KITITAS COUNTY DEPARTMENT OF PUBLIC WORKS

MEMORANDUM

TO: Community Development Services
FROM: Taylor Gustafson, Environmental/Transportation Planner
DATE: June 25, 2018
SUBJECT: County Survey Review of Short Plat SP-17-00002 (Sinclair)

**SHEET 1 OF 2**

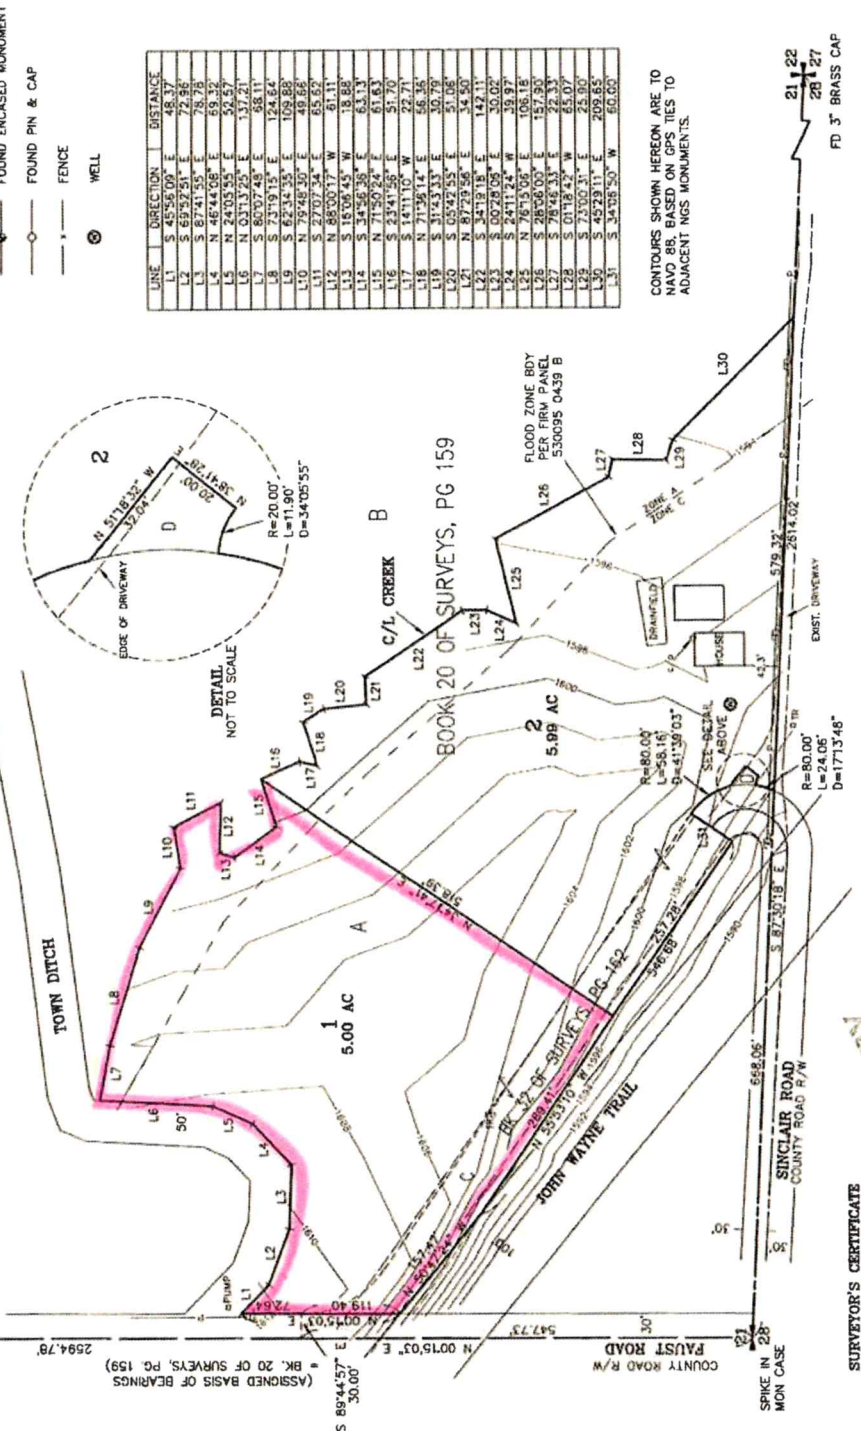
1. Reecer Creek should be labeled.
2. Faust should be labeled as 60' wide.

The South Quarter Corner of Sec 21, is in disagreement with LCR 536433, and a recent survey (ROS 40-192) which call out a pipe and brass cap. Please double check, and if you are in agreement with LCR 536433, please include it as reference.
